**PLANNING JUSTIFICATION STATEMENT**

**SITE AT 7 ACCRINGTON ROAD, WHALLEY BB7 9TD**

A further pre-application was therefore made with a specific aim of obtaining some constructive feedback on the proposed scheme as further revised (Plan no. STA/01a Dwg 03 dated February 2014).

PROPOSED PLANS AND ELEVATIONS	
Site: Proposed Development Accrington Road Whalley	
Client: Mr Tony Stansfield	
Date: 07.10.14	Scale: 1:100 @ A1
Project No: STA/01a Dwg 03	Drawn: DS
Amendments:

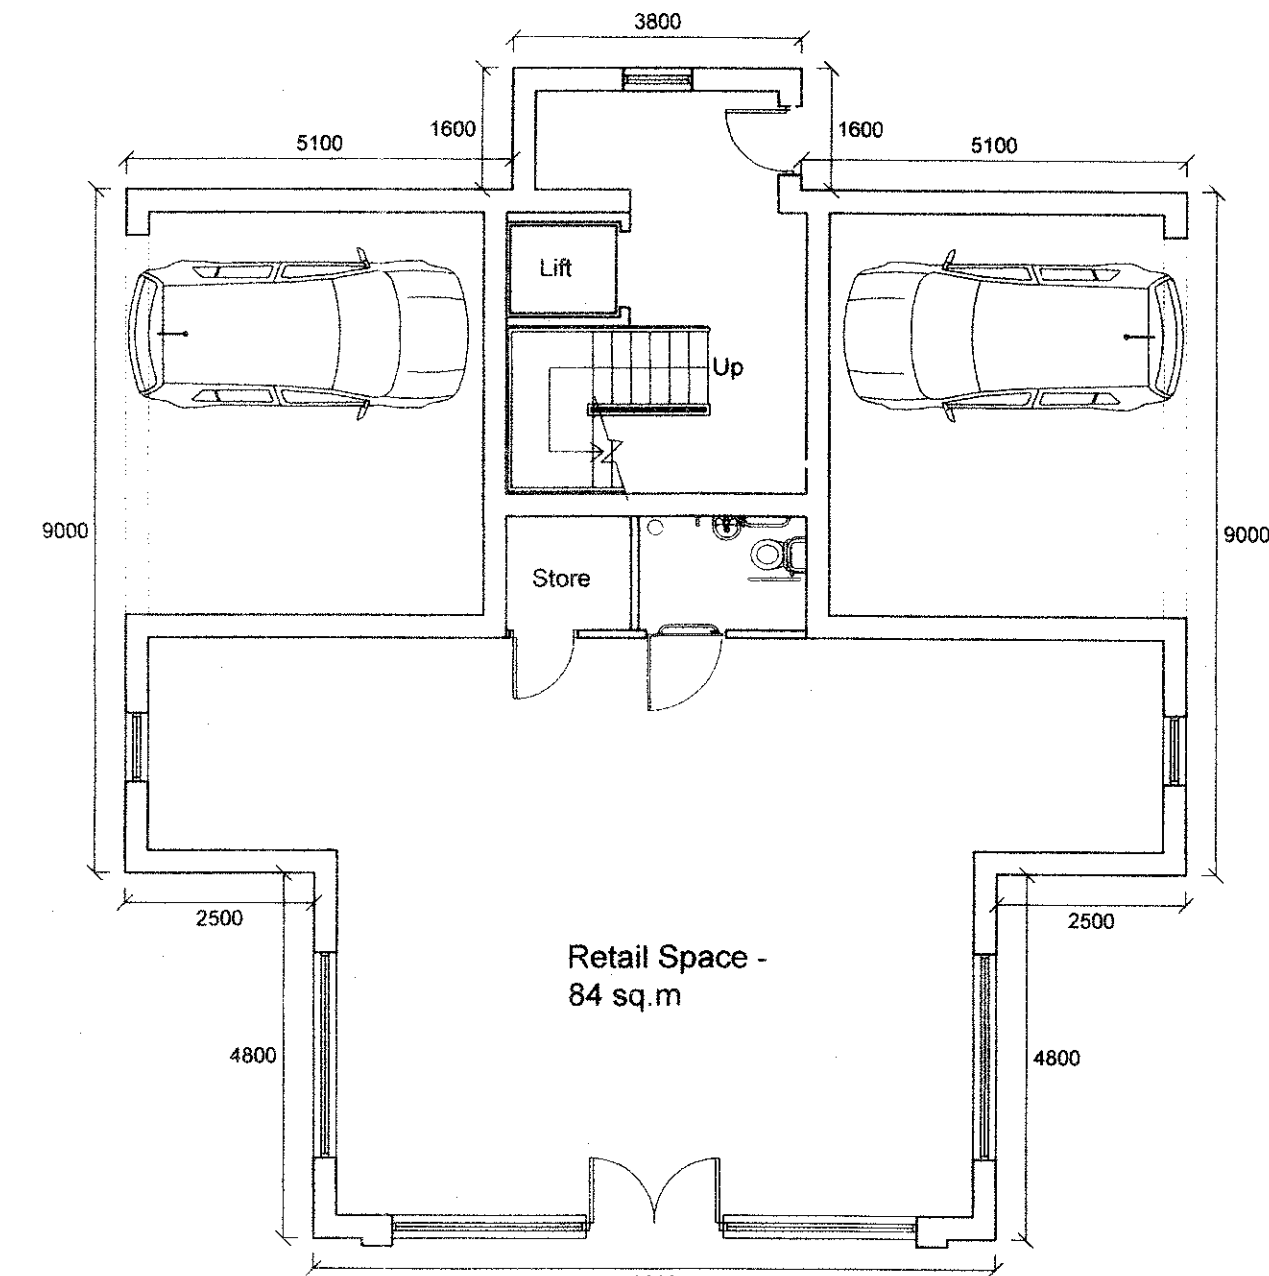
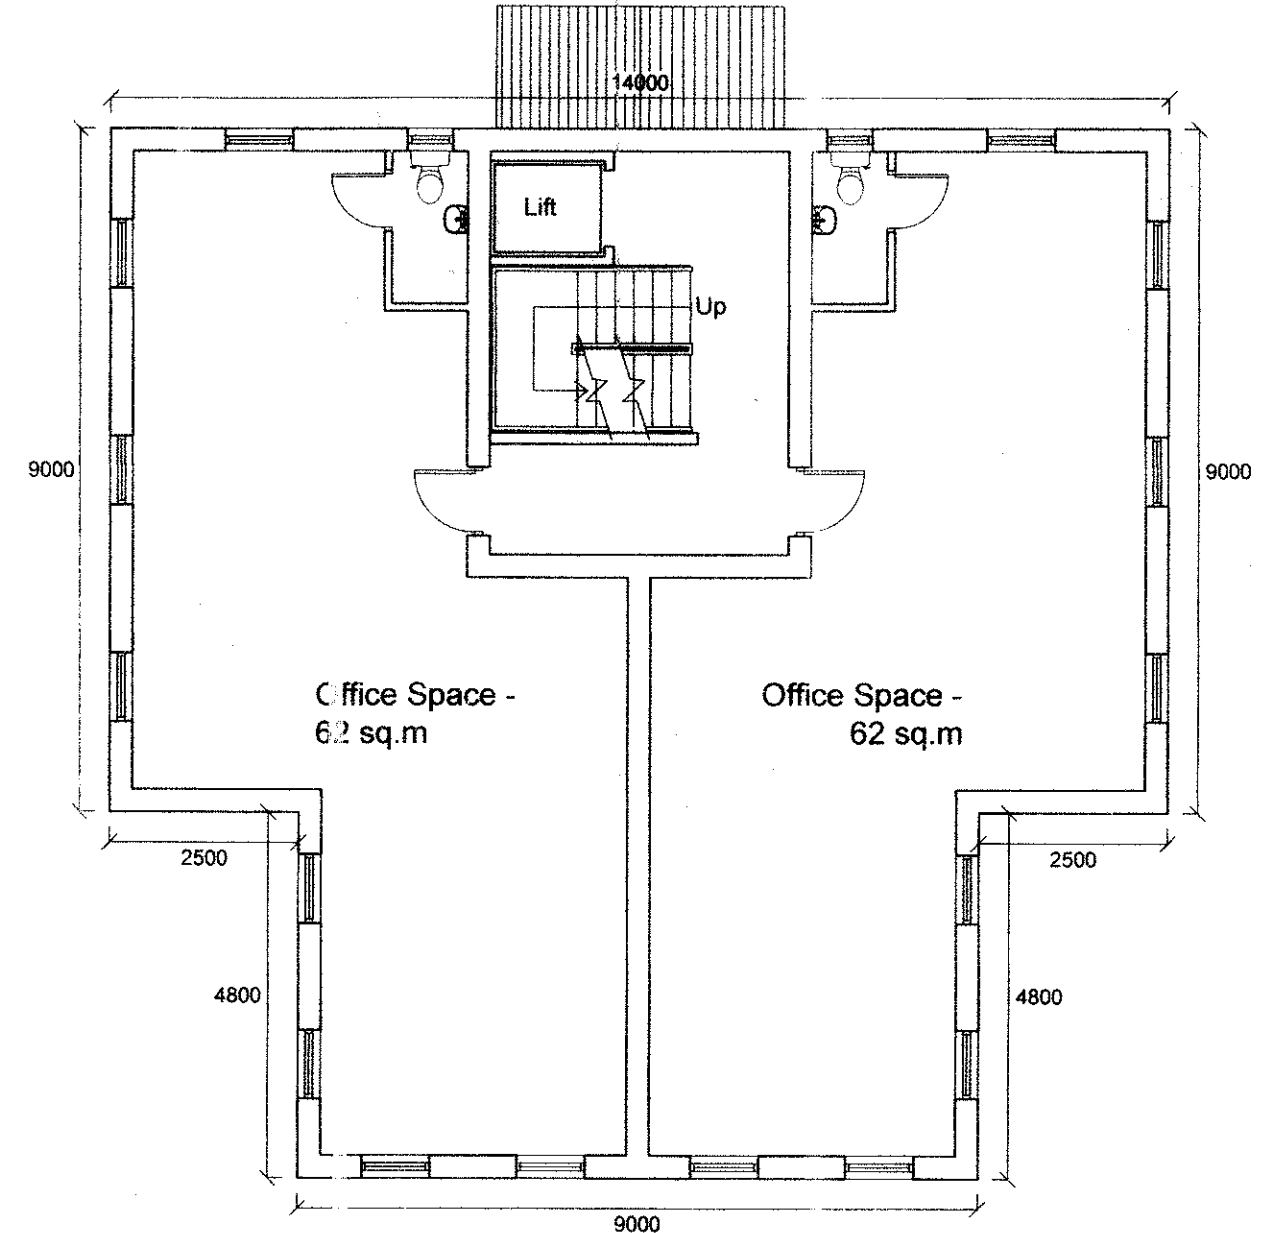
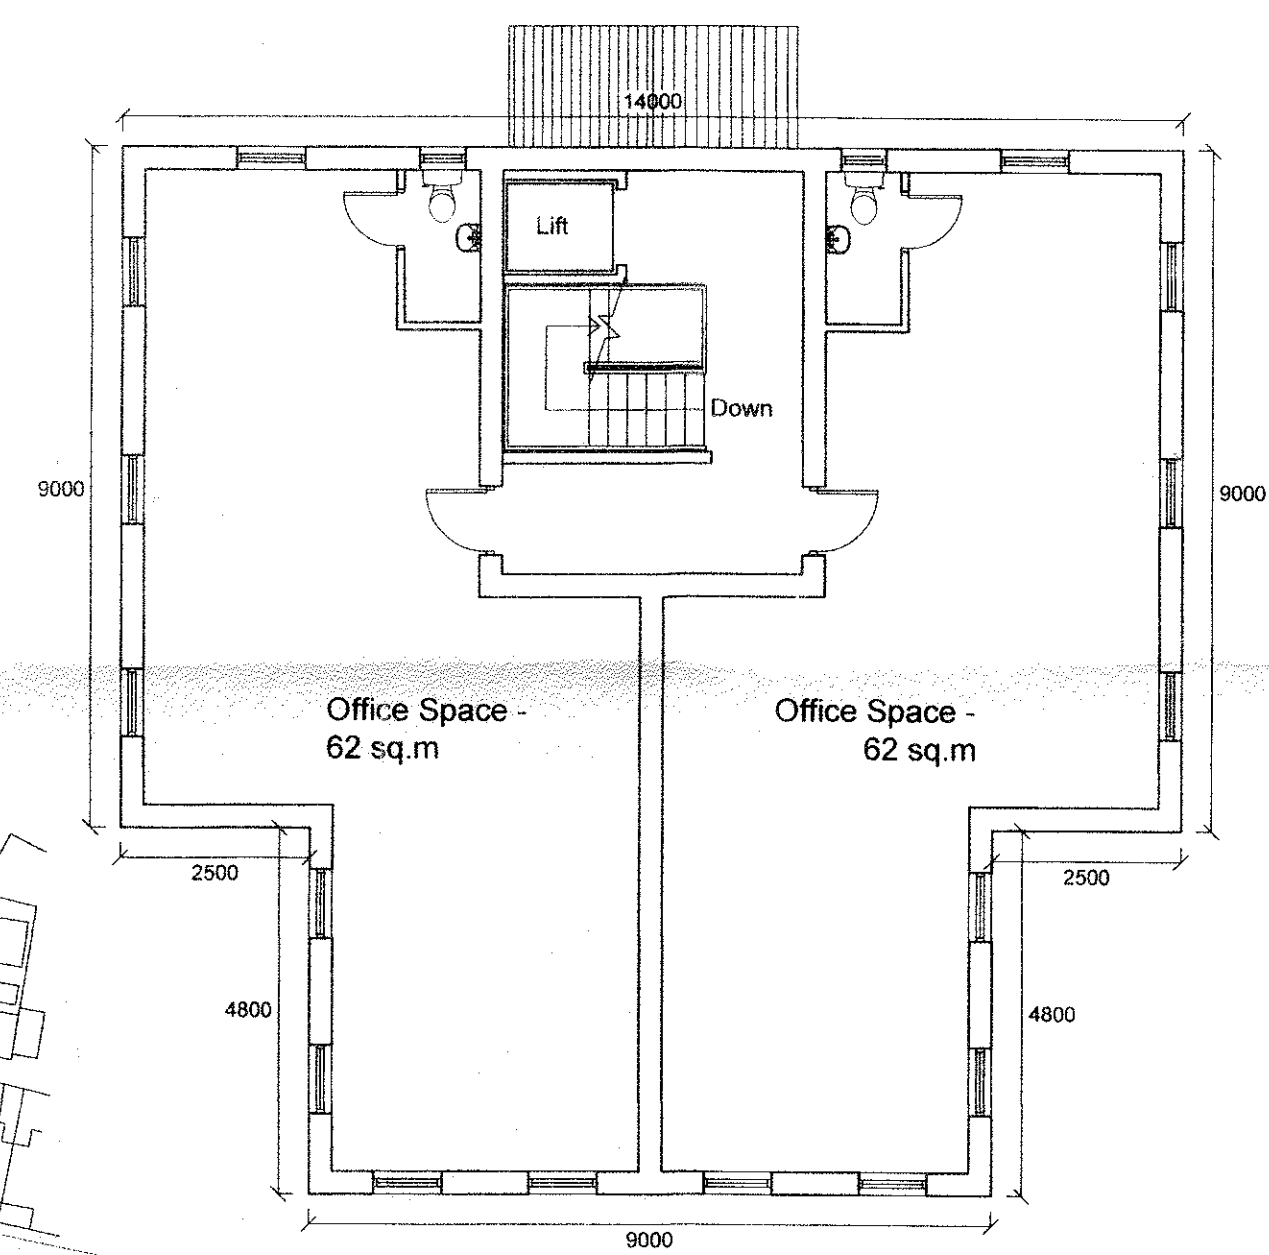
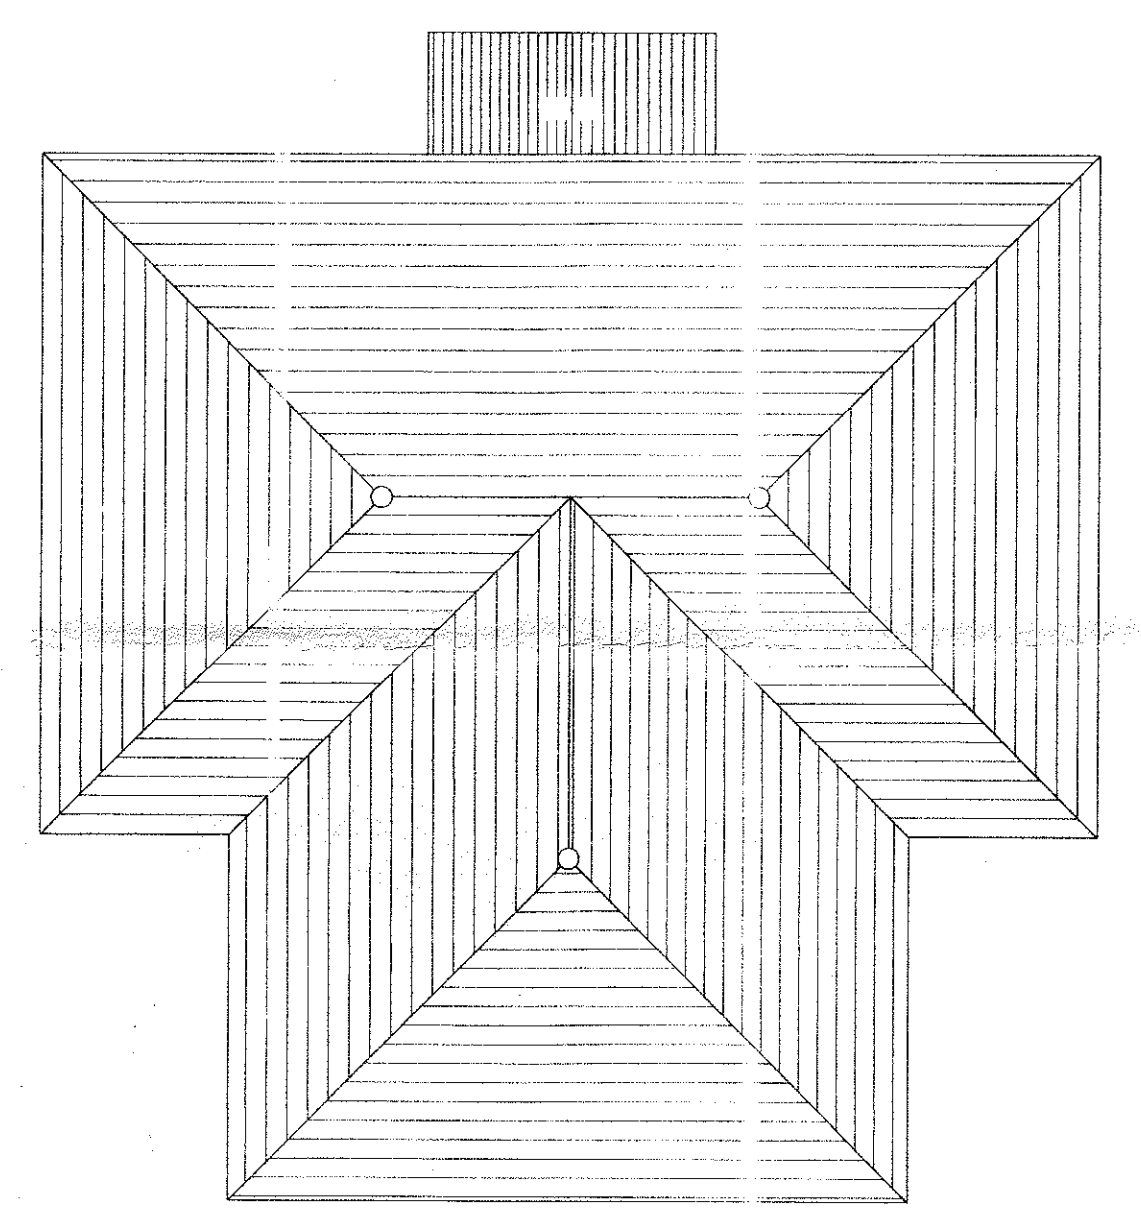
- a) Size and proportion remain with the same slight change to footprint and roof ridge from 9.7m to 10.5m;
- b) Proposal does little to address concerns of hipped roof and uniform detailing, size and proportioning. The proposal cannot therefore be supported and is likely to be refused;
- c) No objection to car parking; request to surface access to sub-station. Issues with location and access to bin storage area and location cycle parking/storage.

For information, there is some discrepancy what the precise design of this most recent scheme is. The proposed roof design as per the colour sketch plans submitted as part of this enquiry differ, insofar as some elevations implies that the ridge height of the main front elevation (shopfront section) is to be 'set-down' from the remainder of the building, yet on some of the other sketches the ridgeline runs through. A request has been made to clarify this and submission of an A1 plan of the proposed scheme as the wrong one (office and residential) was submitted initially), however confirmation of the correct scheme has not been clarified, nor has a plan been submitted. I have therefore assumed that drawing STA/01a Dwg 03 as submitted via e-mail on the 27<sup>th</sup> of November is the correct plan.

In short, and in consideration of the above I am of the opinion that very little has changed from the previous scheme. The size and proportion is in the main the same, apart from a slight change to the footprint and increase to the ridge height from 9.7m to 10.5m. The hipped roof design coupled with the uniform detailing, size and proportioning have previously been expressed as specific areas of concern. Yet this proposed scheme, in my opinion, does little to address these concerns. On this basis, I cannot offer any support to the application as proposed as it is very likely to be refused for similar reasons.

4. The hipped roofs were included because the first designs had gable features and this was considered unacceptable at the time. The reasoning behind the hipped design was to reduce massing to the street front. The hipped roofs have therefore been retained similar to the adjoining buildings. It is interesting to note a hipped roof design has been permitted for the single storey extension to the former police station.

5. The height of the roof ridge had been changed from 9.7m to 10.5m, slightly increasing the pitch. This was deemed necessary to allow sufficient ceiling heights on the second floor; however the height remains the same as the adjoining building to the west.

6. The 'T' shape design of the building was also a response to comments about massing. The design now reduces the impact on the road front.
